Application for a non-material amendment following a grant of planning permission.
Town and Country Planning Act 1990

First floor roof extension over existing single storey flat roof extension. Insertion of dormer to existing southern roof slope.

6. Non-Material Amendment(s) Sought

Drawing Title: Proposed Plans and Elevations		
Drawing Number: 1112.02.d		
Scale: As stated printed @ A1		
Date: 20/07/2017

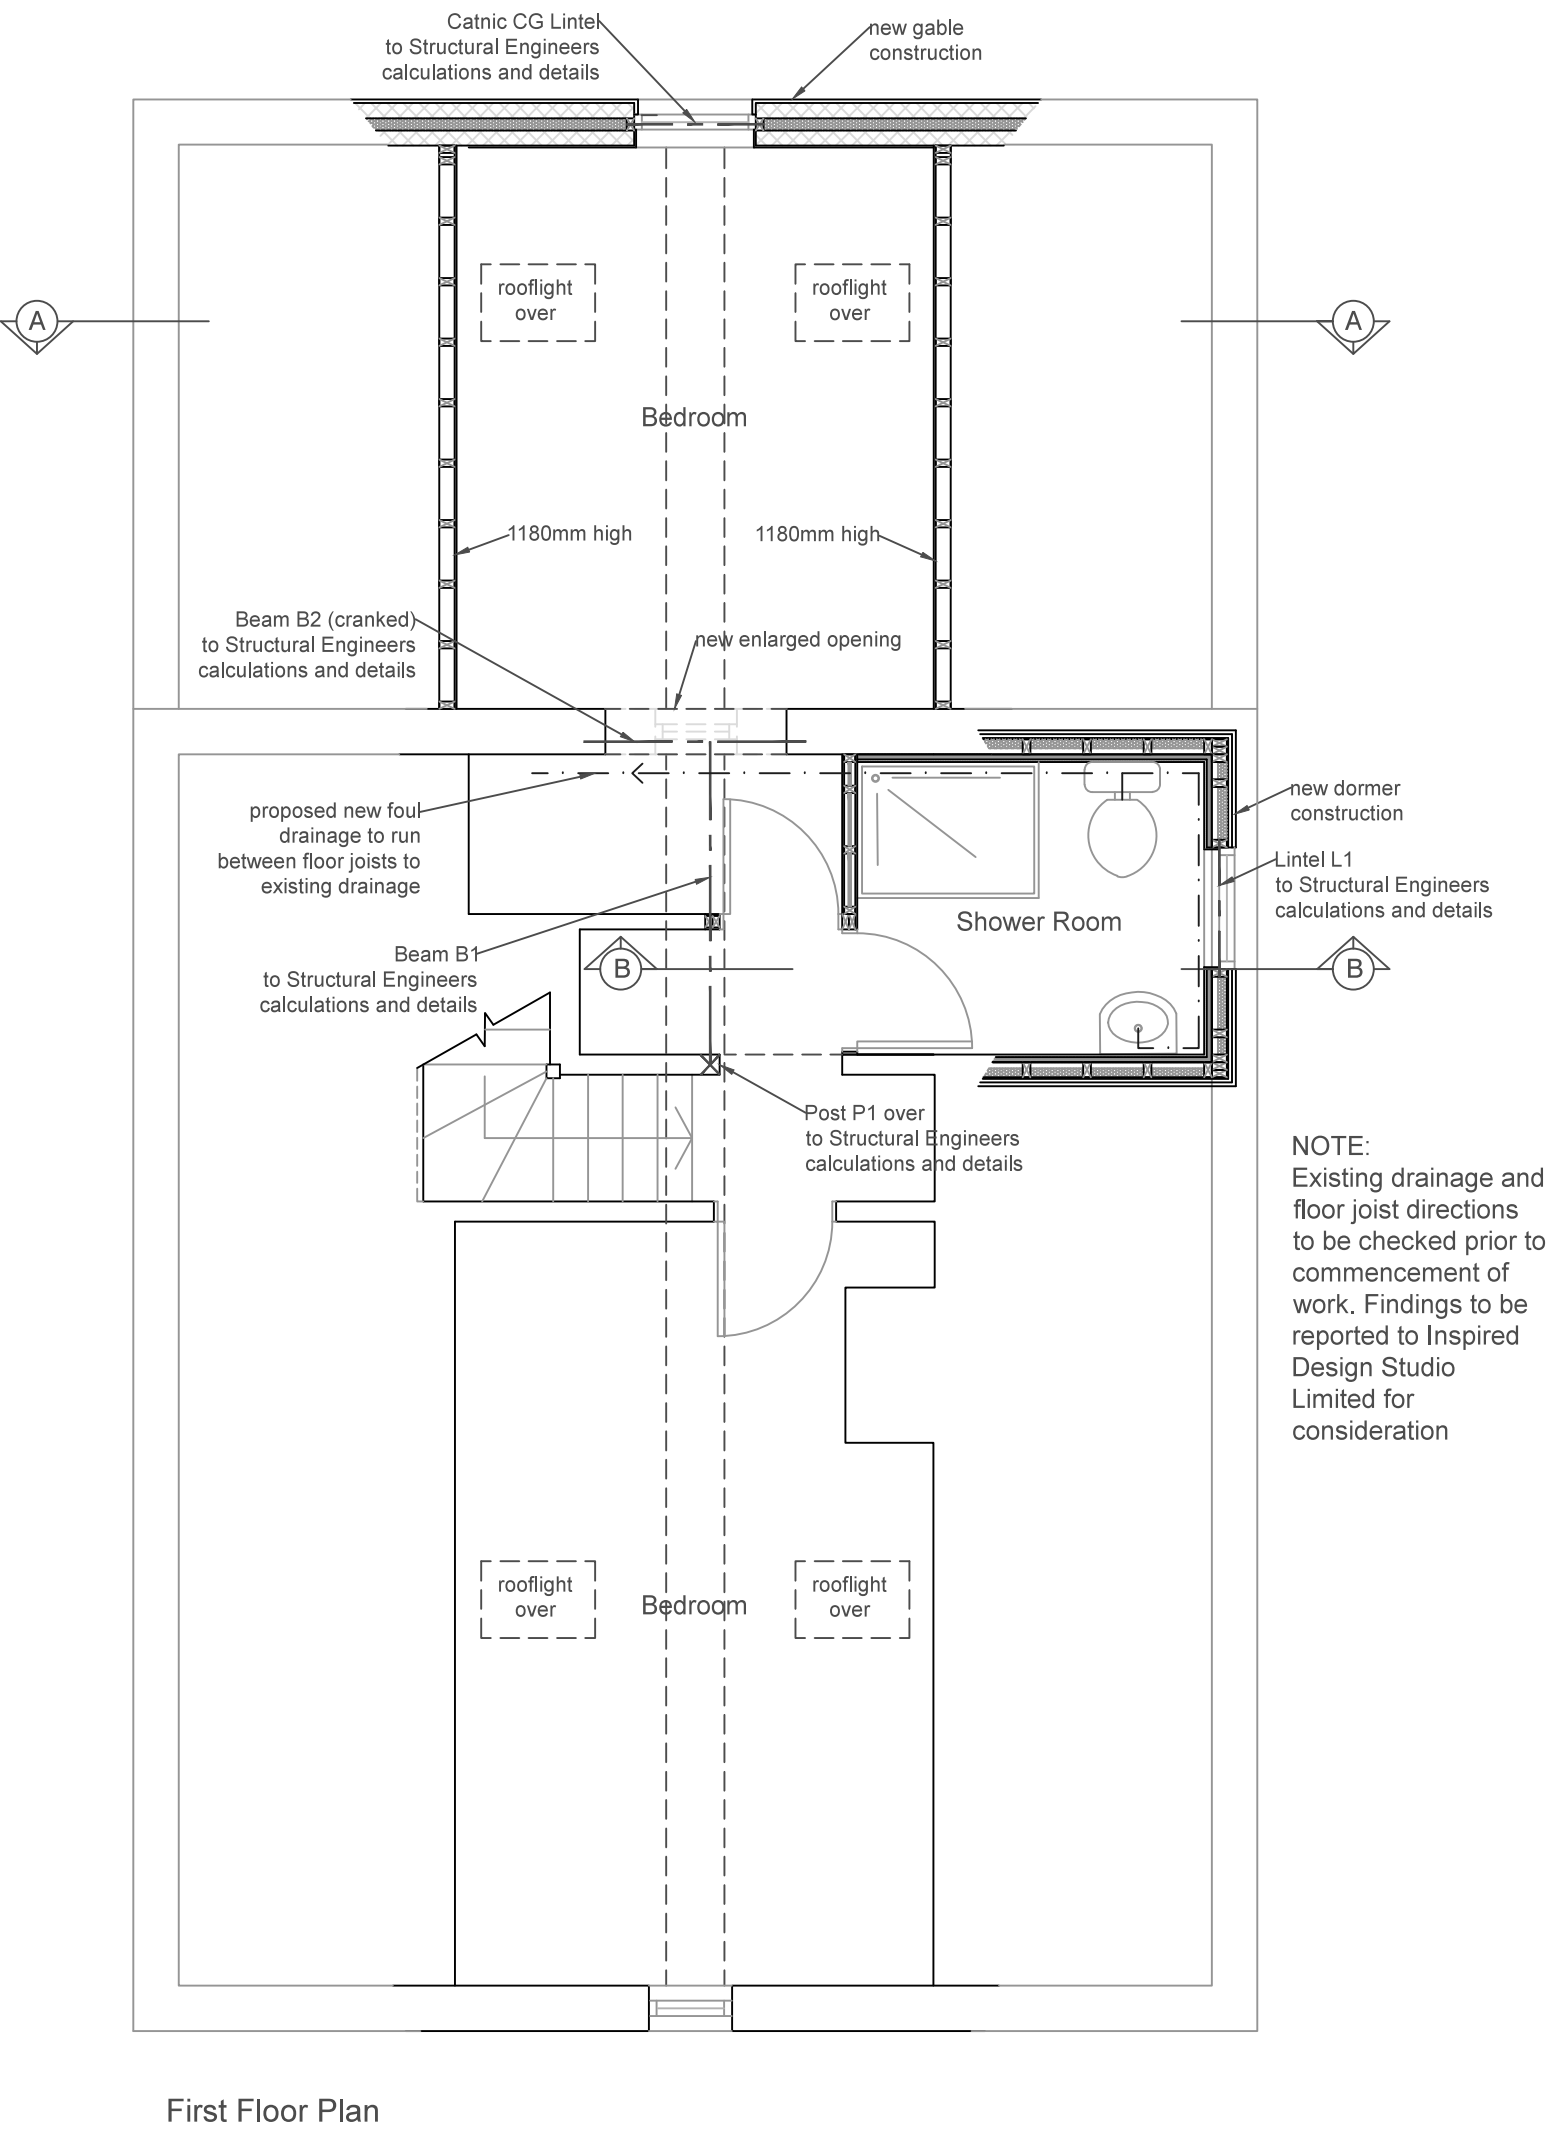
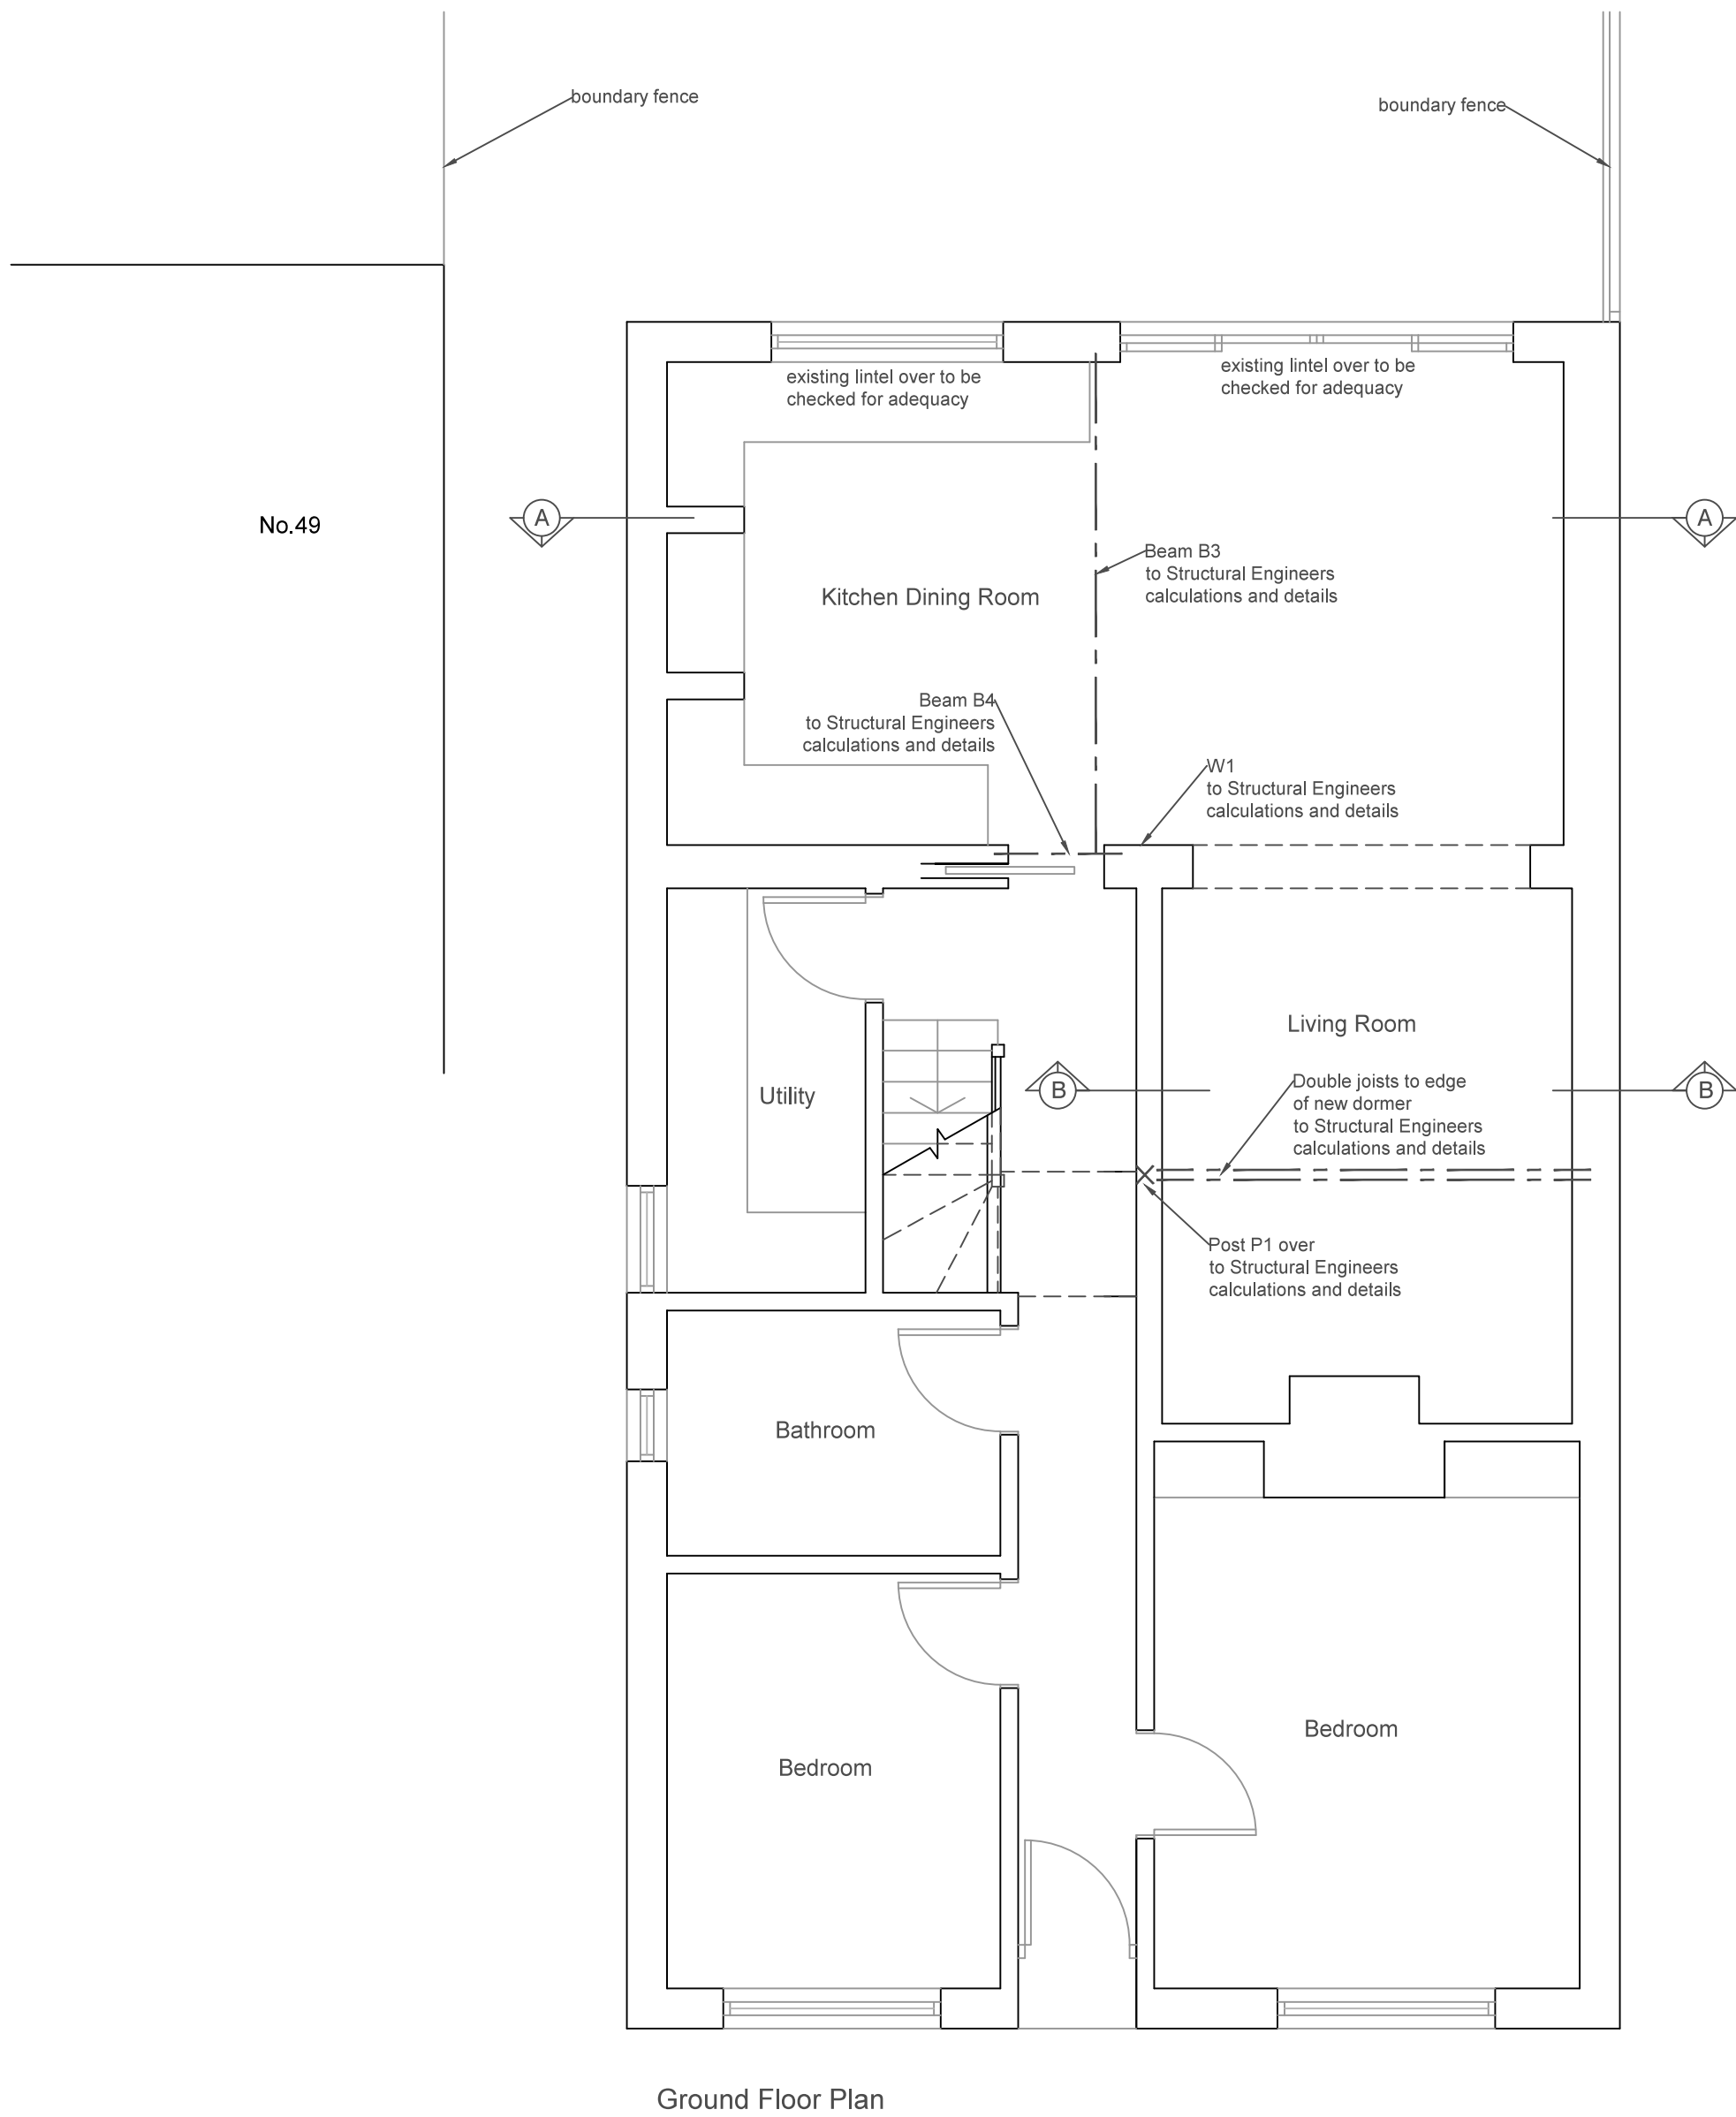
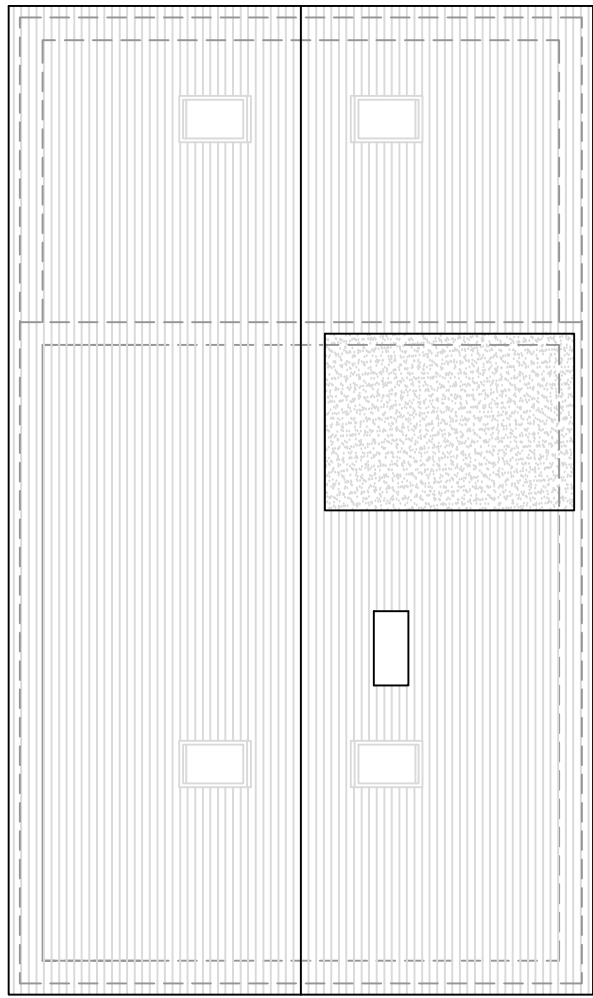
Addition of two velum's to proposed new roof, one to north roof slope and one to south roof slope. Addition of cedral cladding to new rear gable at first floor level.

Velux's required to provide more light to proposed bedroom.
Cladding requested for aesthetics and because it is easier to maintain than render.
